Engineers Comments Regarding Surface Water Drainage

Application Reference:	M/39/24/DOC	Reviewer Reference:	ADC/PC
Planning Officer:	Kathryn Welch	Date of Review:	08/09/2025
Site Name:	117 Elmer Road Middleton-on-Sea PO22 6LH		
Application Description:	Approval of details reserved by condition imposed under reference M/84/23/PL relating to condition number 7 - surface water drainage scheme.		
Assessment Number:	1 of 2

Application Reference: M/39/24/DOC Site Name: 117 Elmer Road Middleton-on-sea PO22 6LH	Initial Issue Date: 03/09/2024 Issue Date: 08/09/2025 Reviewer Reference: ADC/PC	
---	--	--

OBLIQUE JUNCTION CONNECTION

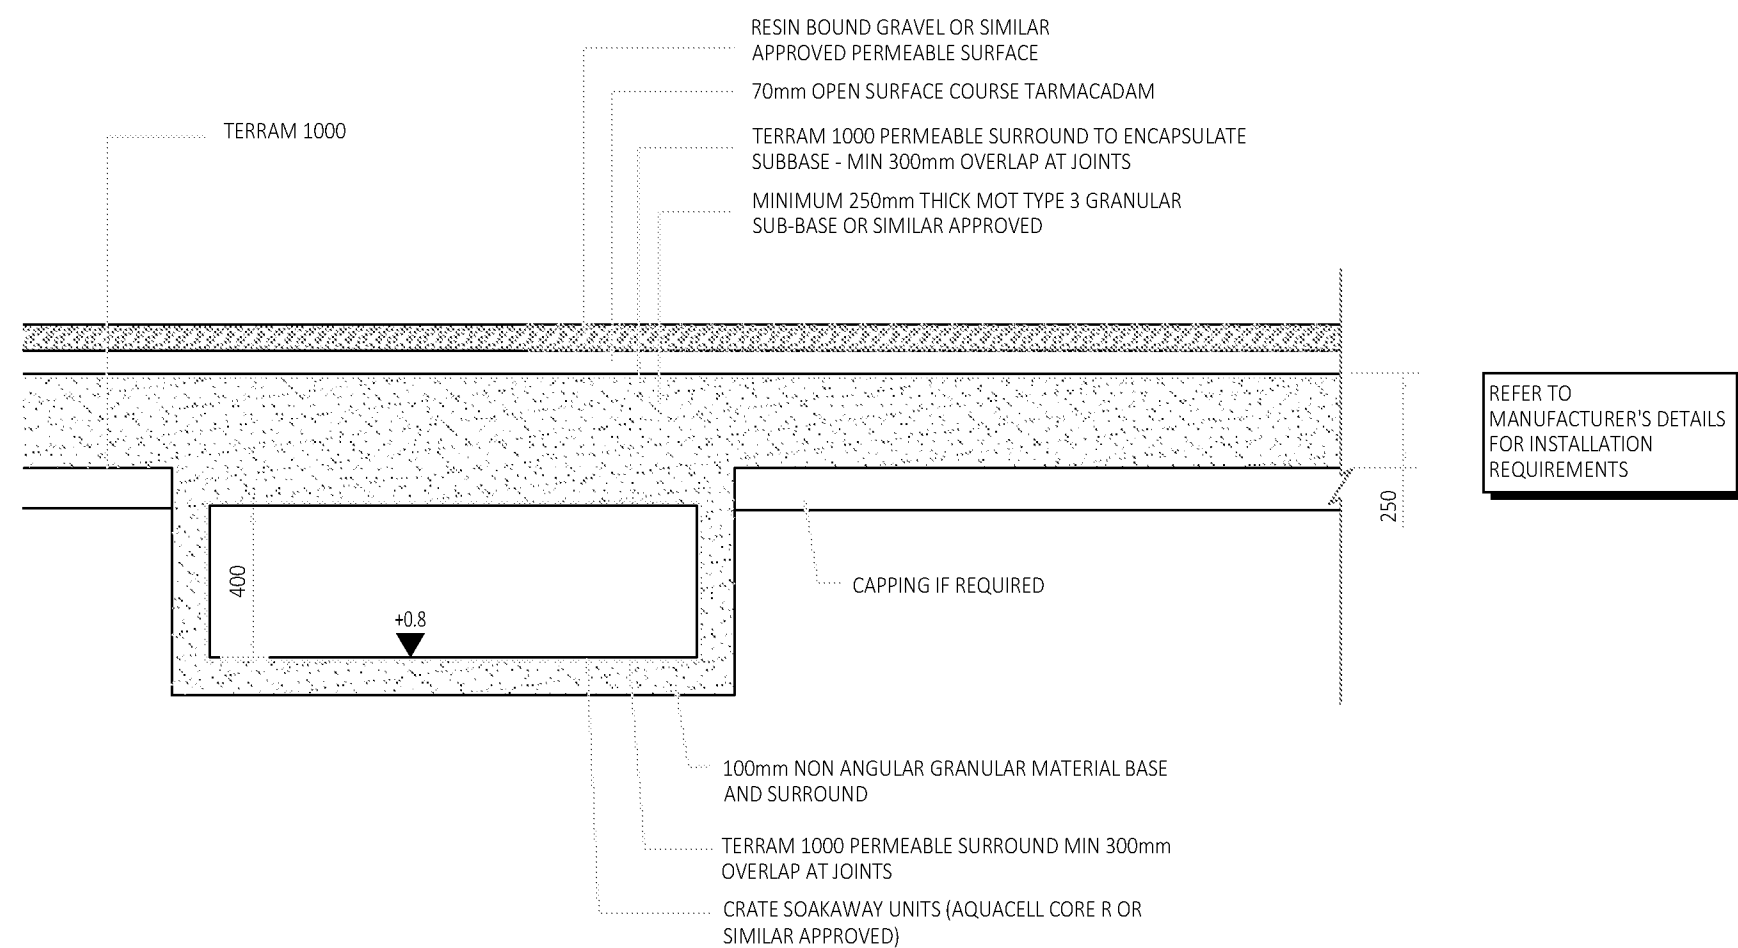
30.				Please provide construction detail for oblique pipe to pipe connections/junctions.	Please remove the 90 degree option from construction detail, as 45 degrees provides better hydraulics.	A saddle connection construction detail has now been provided instead. This is not acceptable for pipes of the specified diameter. Please revert to the junction type connection but with th 45 degree connection angle as previously requested.

TYPICAL CRATE SOAKAWAY

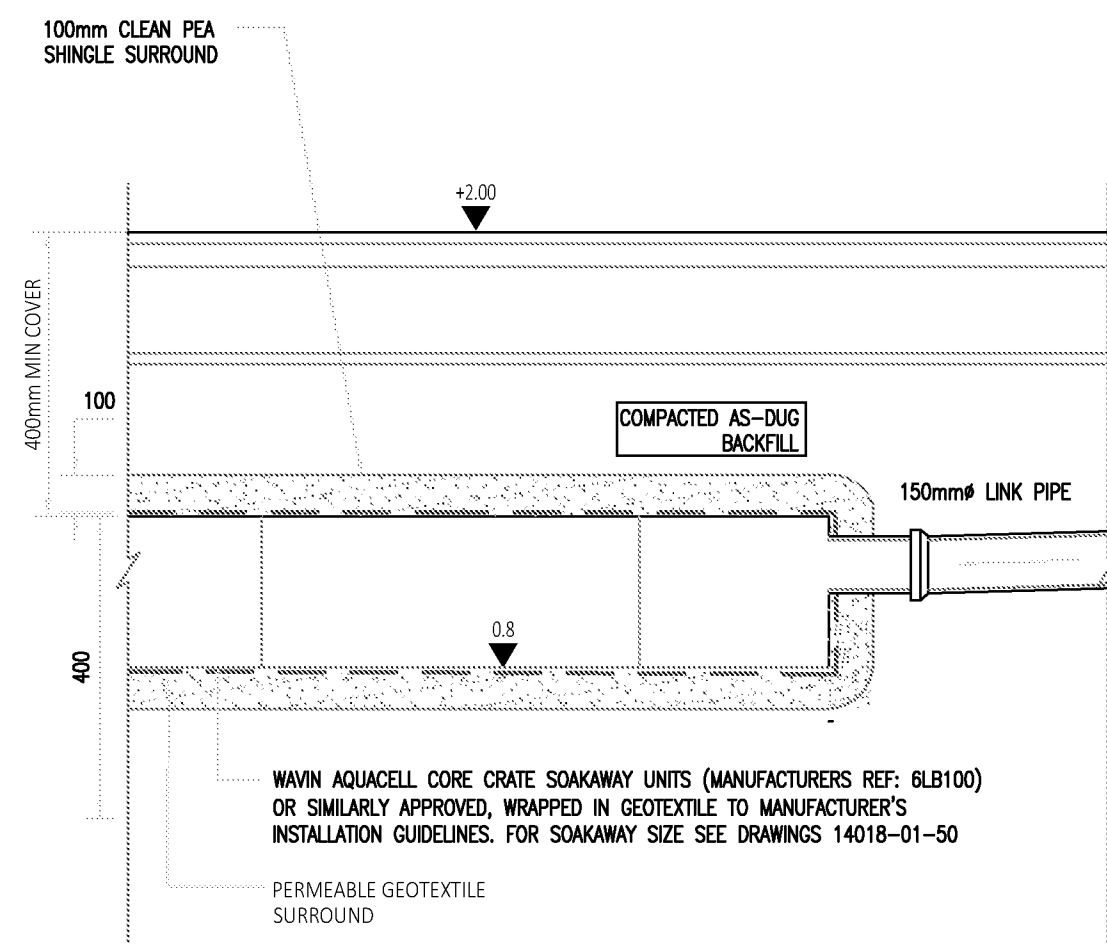
26.				Please specify catch pit diameter.	Ok. Point closed.	
27.				Typical crate soakaway refers to a slotted pipe, it is not clear why. Please adjust.	Ok. Point closed.

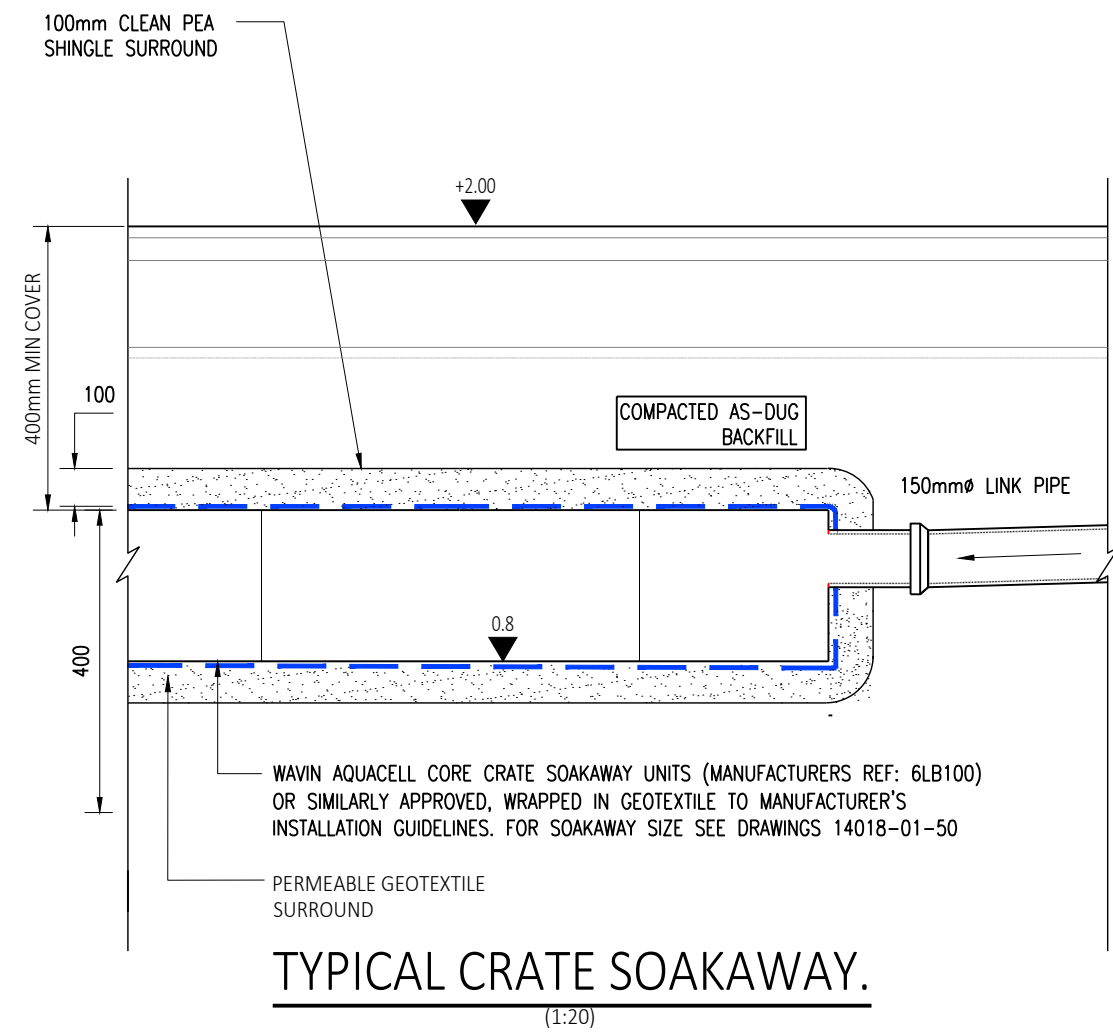
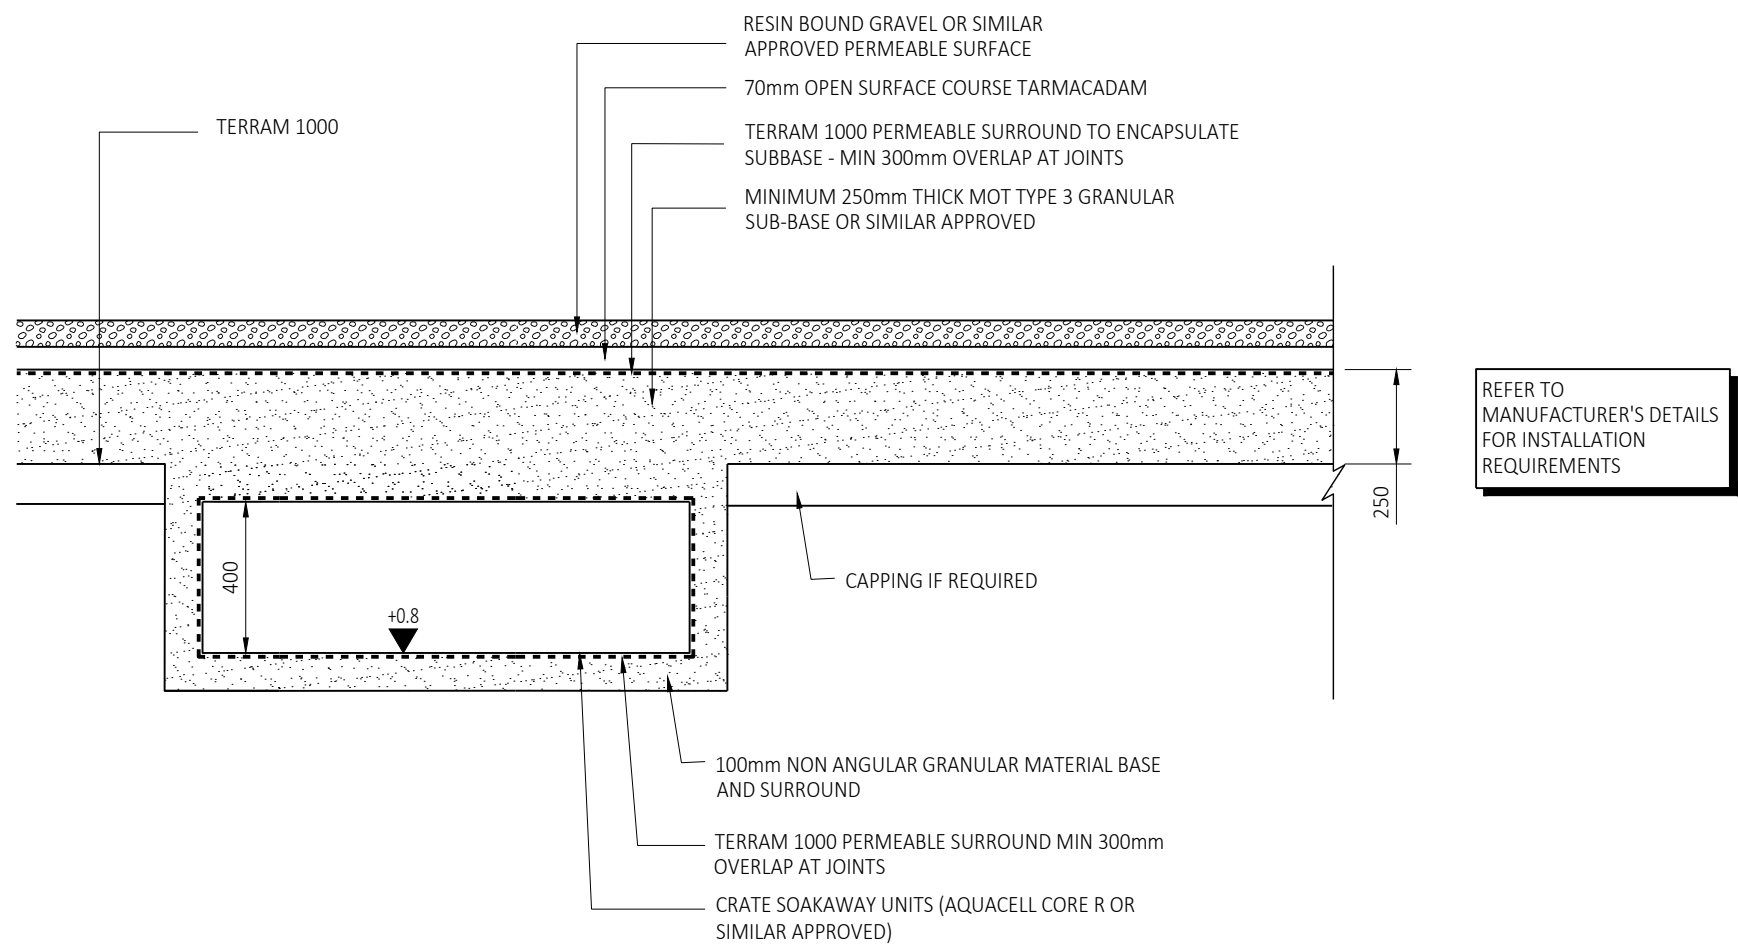
21.				Soakaways must be set at 1.2m below ground level to accord with the infiltration testing (see point 1). Therefore, the soakaways must be set deeper.	Design revised. However, the layout plan shows the soakaway bases set at 0.4m AOD as opposed to 0.8m AOD. The construction details show it correctly. Please adjust accordingly.	Rear soakaway bases have not been adjusted.
